2024/0645

79 Barnsley Road, Dodworth, Barnsley, S75 3JS

Erection of detached garage and 1.7-metre-high boundary wall (Amended Plans and Description).

TITLE
Proposed Garage Plan & Elevations

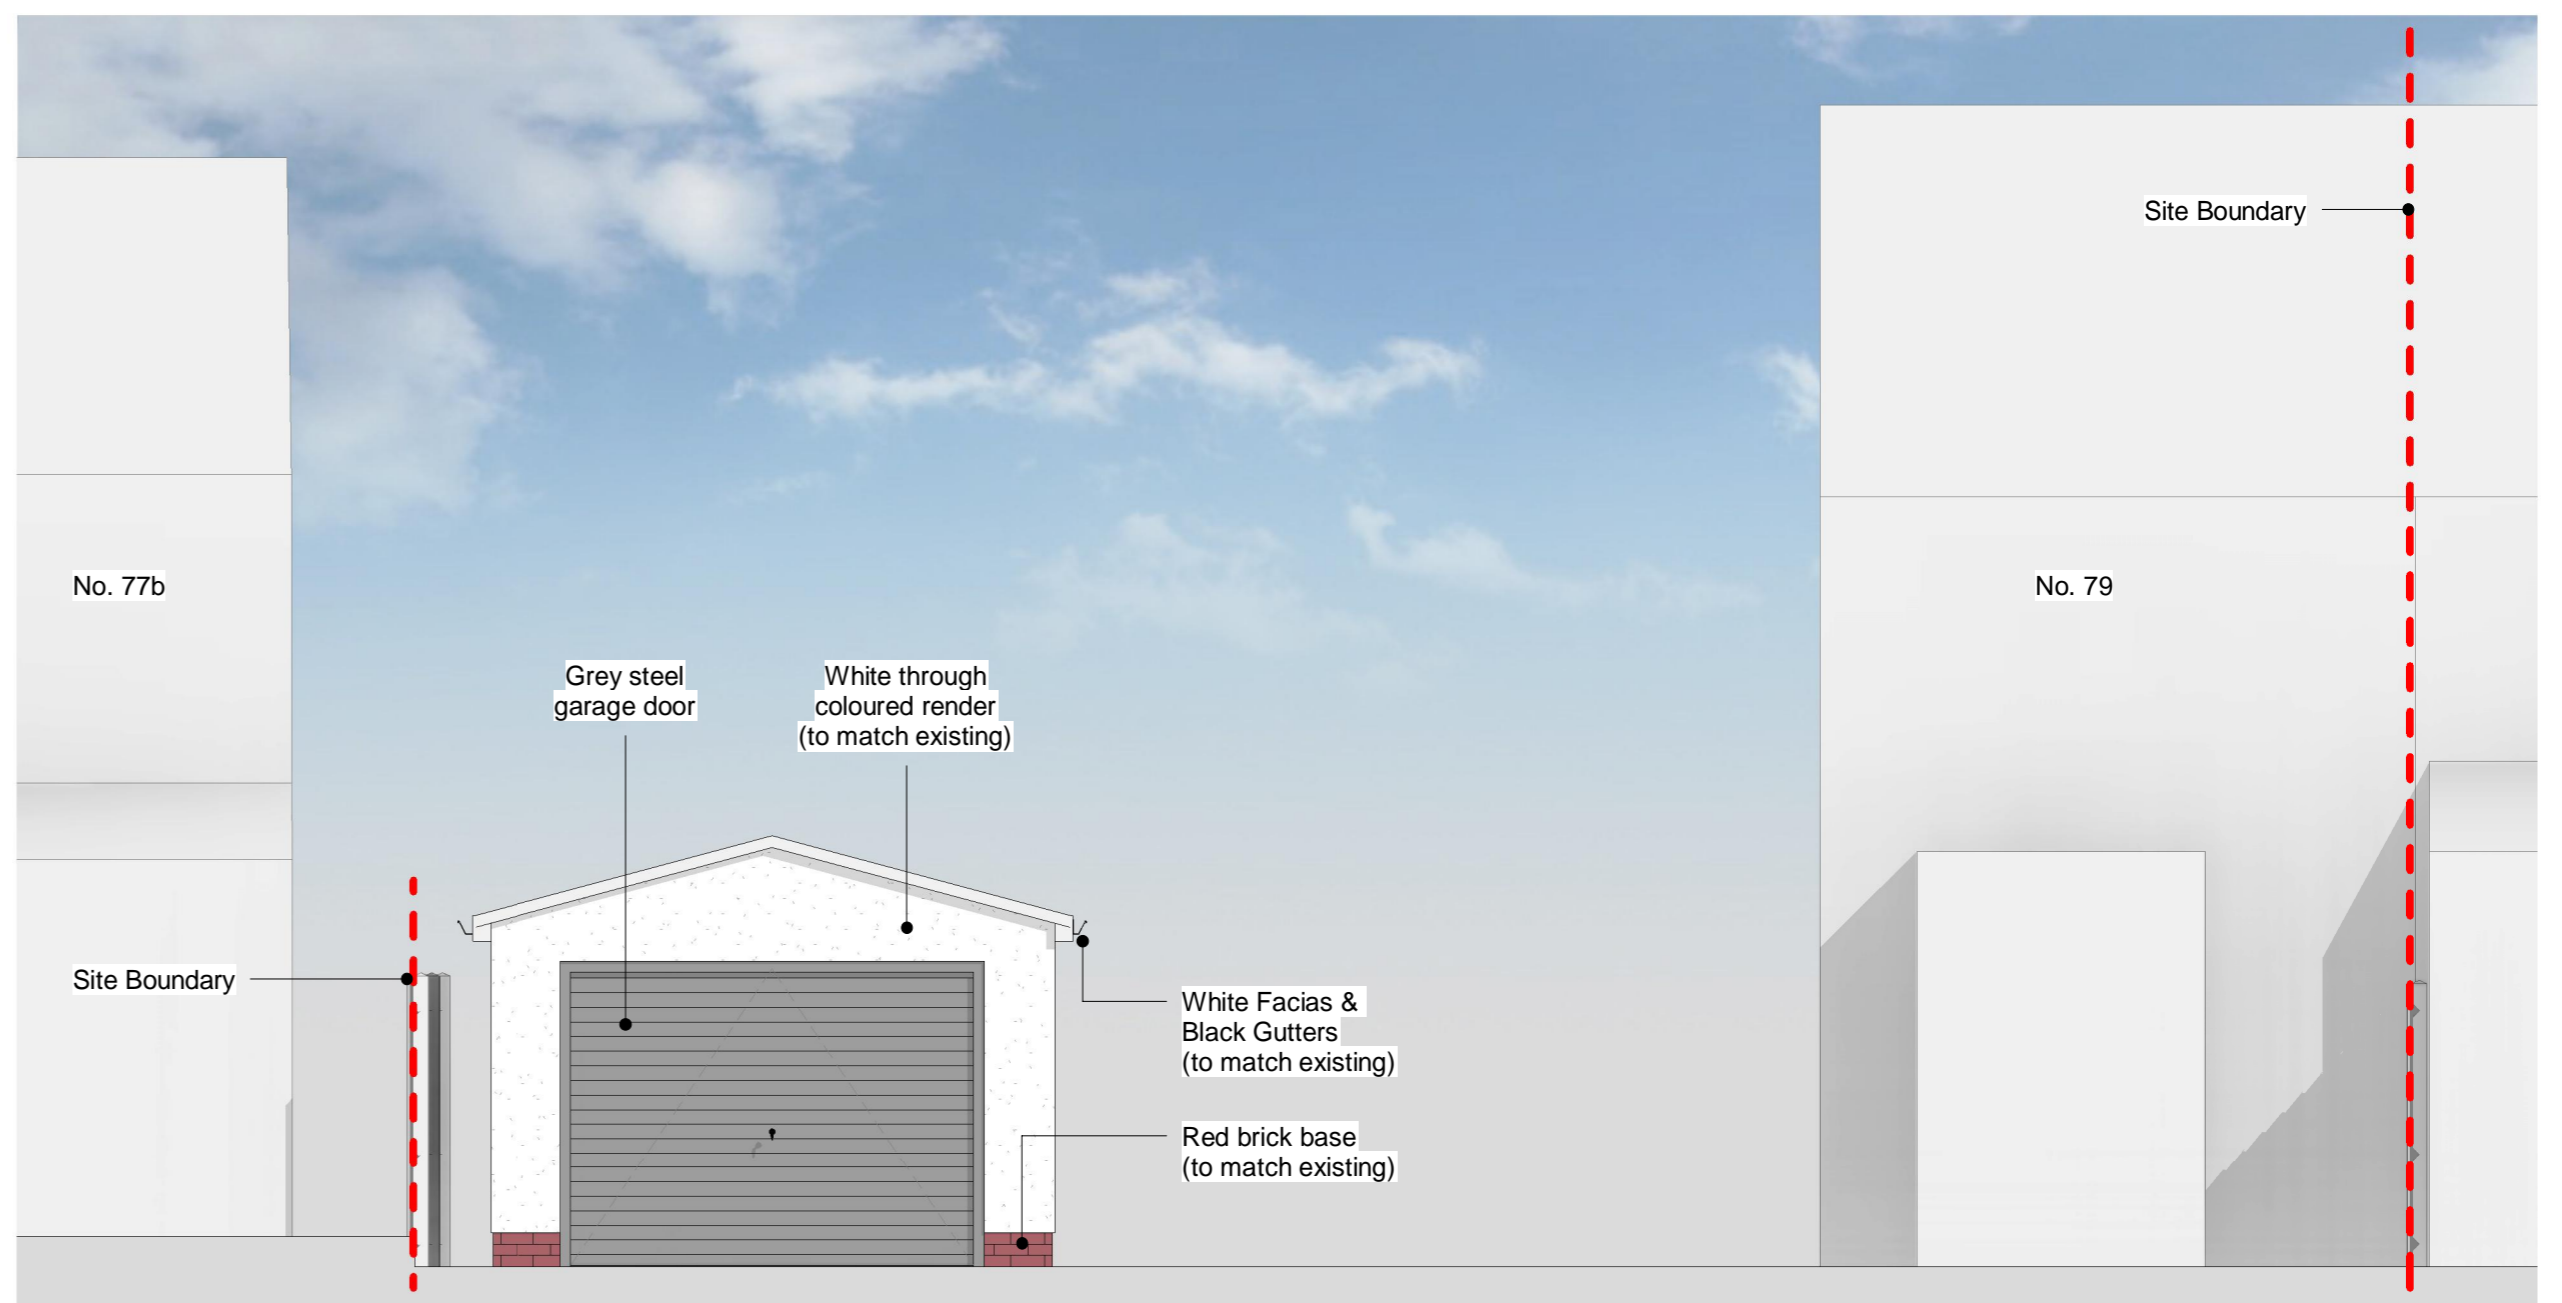
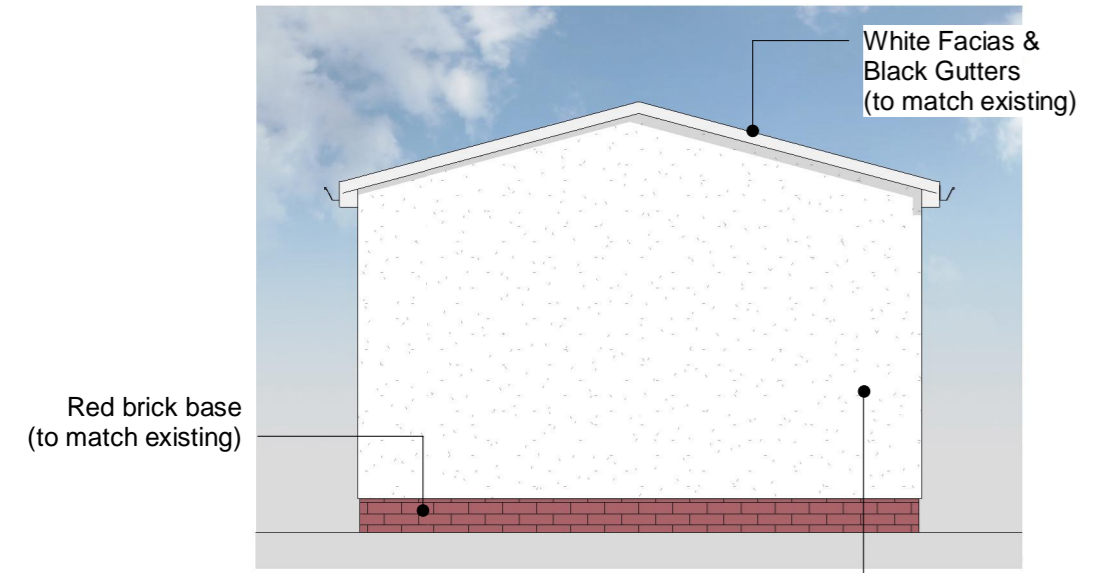
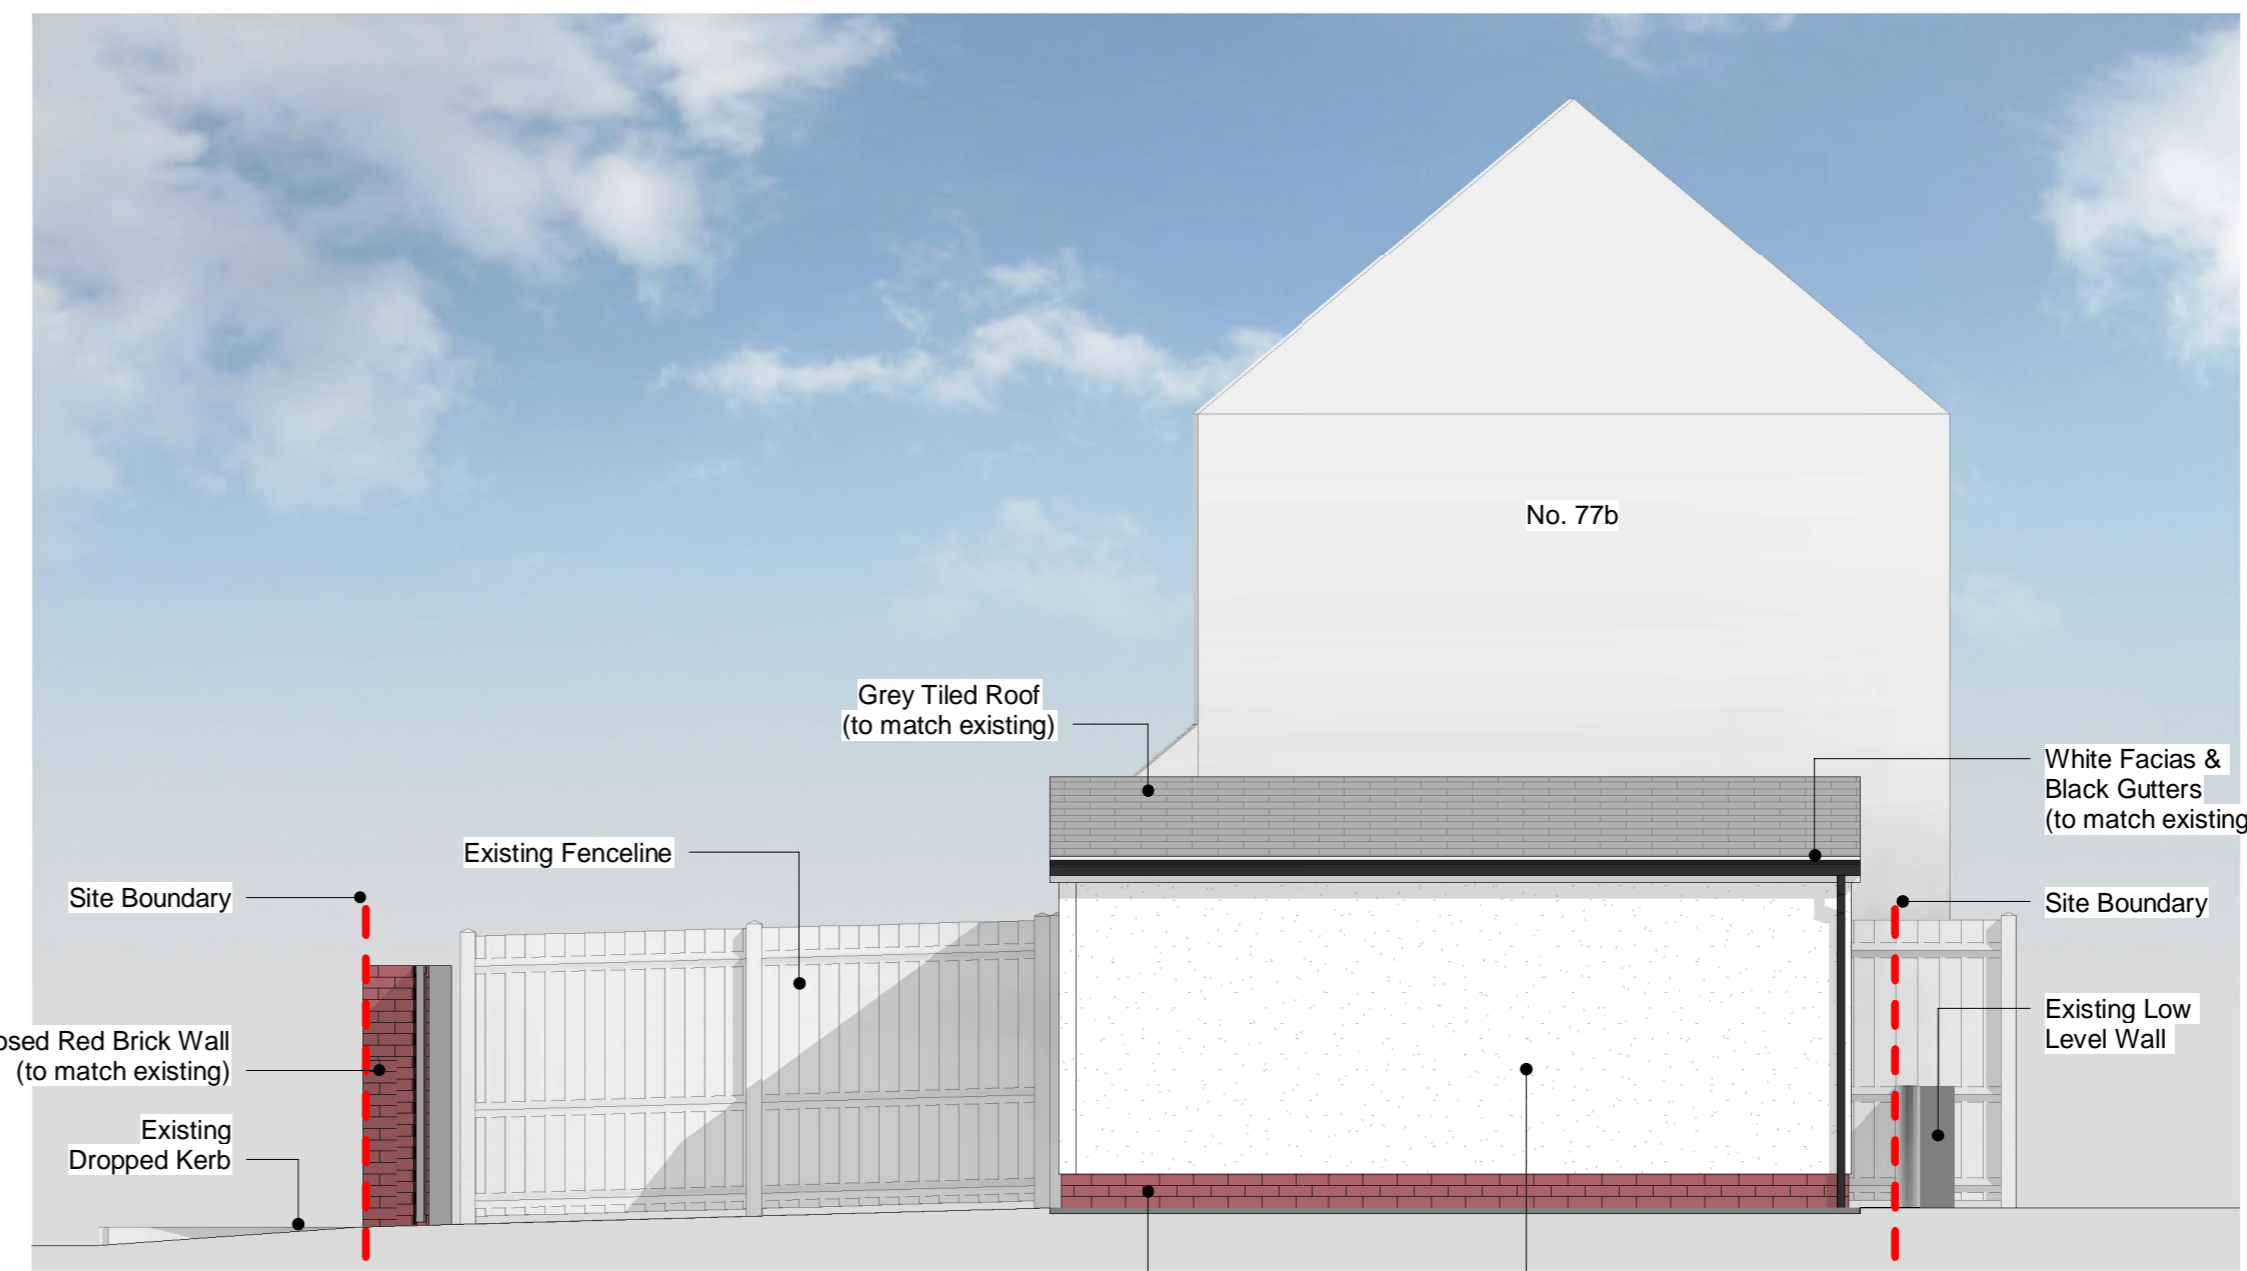
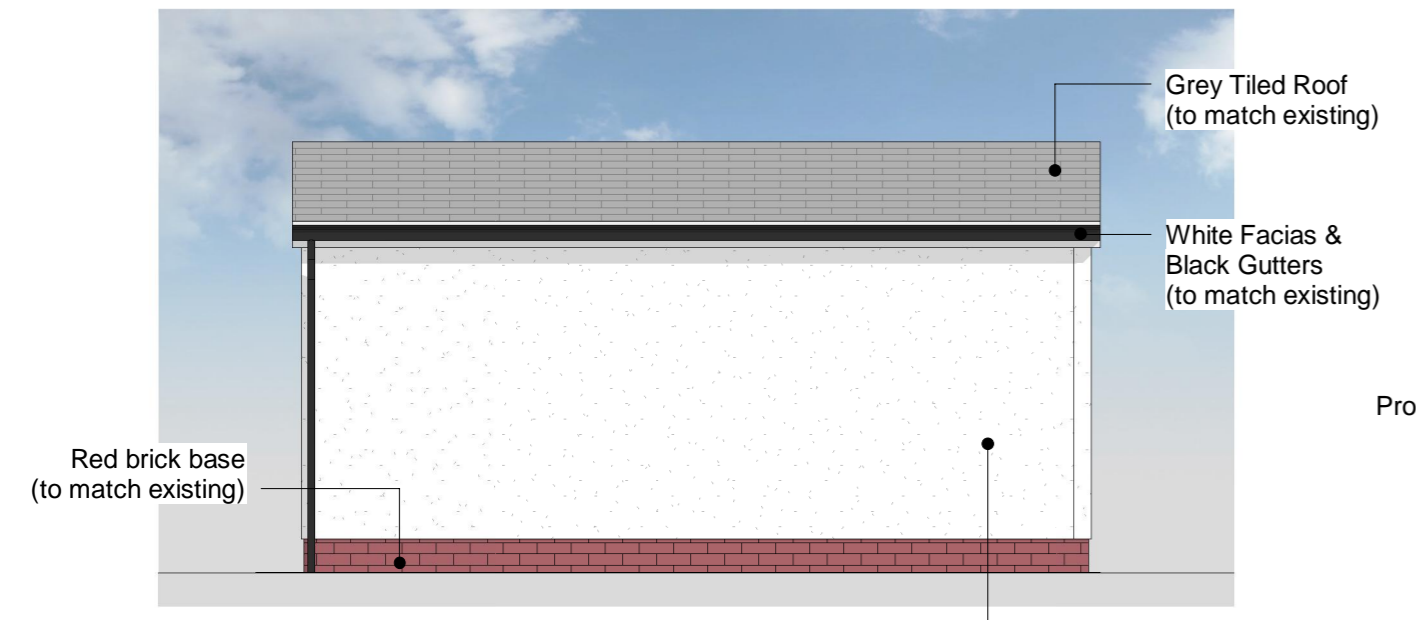
- The proposed garage does not meet the requirements of the SPD, that is, the garage should be 3.5m x 6.5m.
- The proposal will mean vehicles will need to reverse onto the B6449, which is unacceptable. Currently the driveway has space however, if a garage is built there then there will be no space to turn the car, and this will mean he will have to reverse onto a very busy road which leads onto the motorway and is always constantly used even in off peak hours.

- The garage is proposed to be render; this does not reflect the host property.
- Highway safety is a concern as there is a junior and infant school across from the property and parents' park on the main road outside 79, 81 and 83 Barnsley Road and children walk past the already built wall which has not had planning permission.

During the application process, an objection raised concerns that the rendering of the garage would not reflect the appearance and character of the application property. However, light-coloured render is commonly utilised throughout the street scene of Barnsley Road and the broader locality. The rendering would therefore not significantly alter or detract from the character of the street scene and is considered acceptable. Moreover, while the garage would be visible from the surrounding public realm, its prominence would be lessened due to the screening that would be provided by the front boundary wall. The garage would also adopt a sympathetic form and features, including a gable pitched roof with grey roof tiles and a modest scale that would sympathetically reflect the proportions of the application property.

During the application process, the proposed garage was amended to significantly reduce its size. The revised garage would have internal dimensions of approximately 3.5 metres by 5 metres which would fall below the minimum requirement of 3 metres by 6 metres to be classed as a parking space. However, the reduced garage size results in a larger driveway that could accommodate a minimum of two off-street parking spaces with dimensions of 2.5 metres by 5 metres in accordance with the parking SPD. There would also be space available within the application site for vehicle turning.

**Proposed Site Plan**

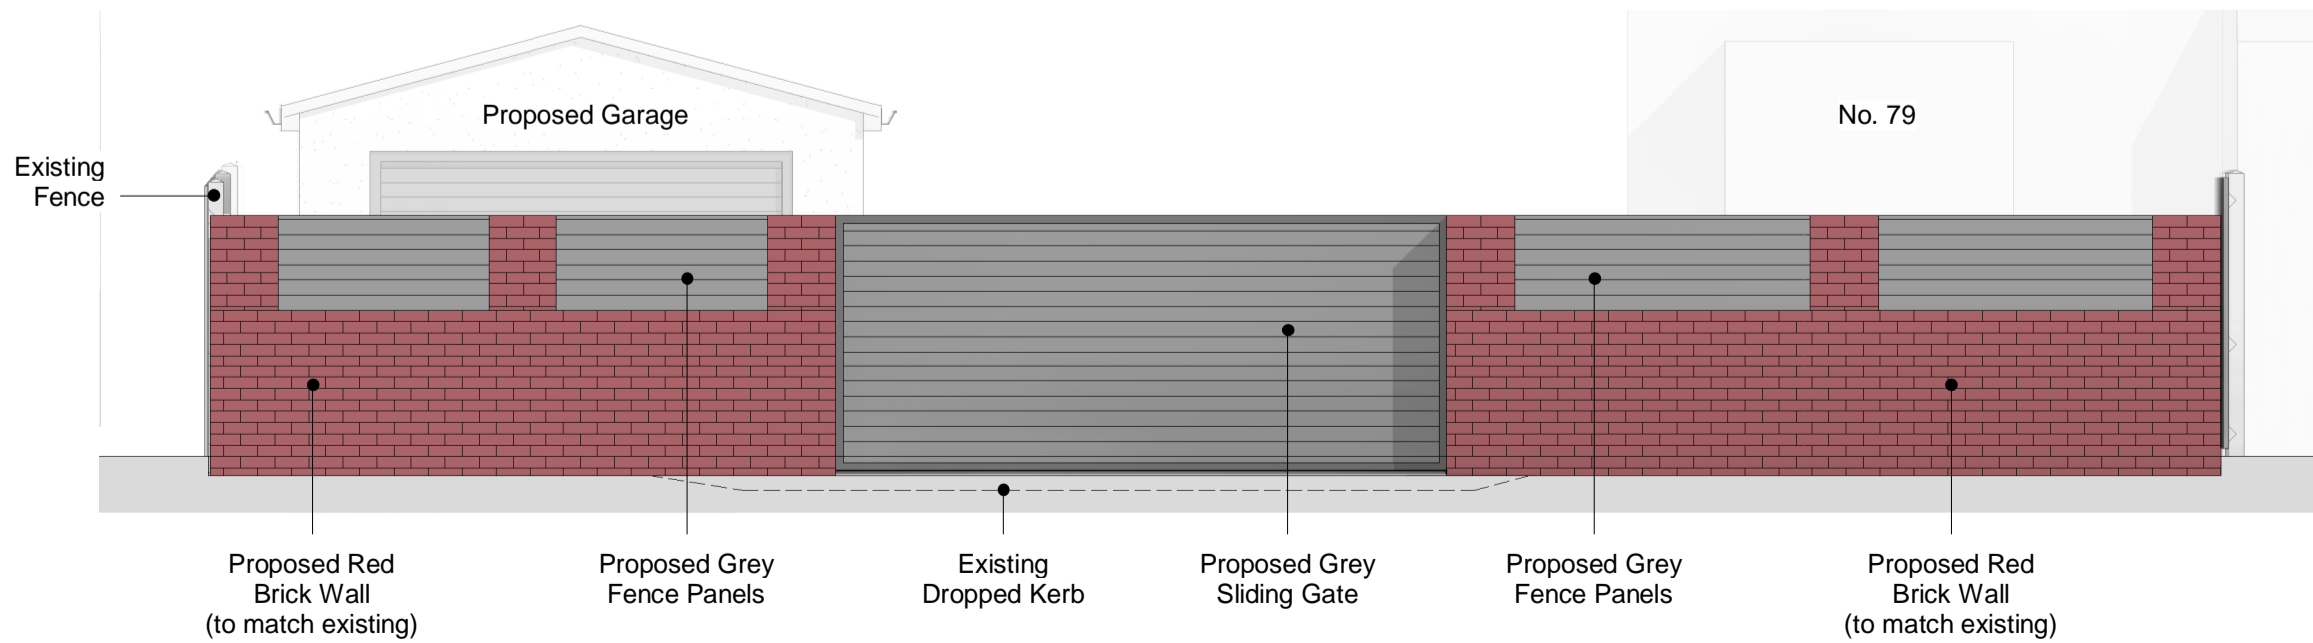
- Vehicles exiting the existing and proposed parking spaces do not have the required visibility splays and the proposed 1.7m high wall will be unsafe to passing pedestrians and vehicles on the B6449.

The boundary wall has been erected with an access opening of approximately 4 metres wide which would allow for the required pedestrian visibility splays to be achieved. The height of wall would also be similar in height to the previous fencing.

A Council Highways Engineer was consulted on the application. While no concerns have been raised in relation to off-street parking and visibility, the sliding gate was identified as an area of concern due to the potential of waiting vehicles that could cause an obstruction to vehicles and pedestrians. This concern is compounded by the fact that there is a bus stop immediately opposite the application site and parking restrictions in place due to a nearby school. Subsequently, the sliding gate was removed from the proposed scheme which would address the concerns of the Highways Engineer. A further response was received acknowledging the removal of the gate and outlining no objections subject to conditions. However, the only recommended condition to be included will be the condition in relation to visibility splays. This condition will be included with amended wording. The other recommended conditions will not be included as it is considered that they do not meet the tests required in that the conditions are not considered to be necessary or relevant to the development to be permitted.
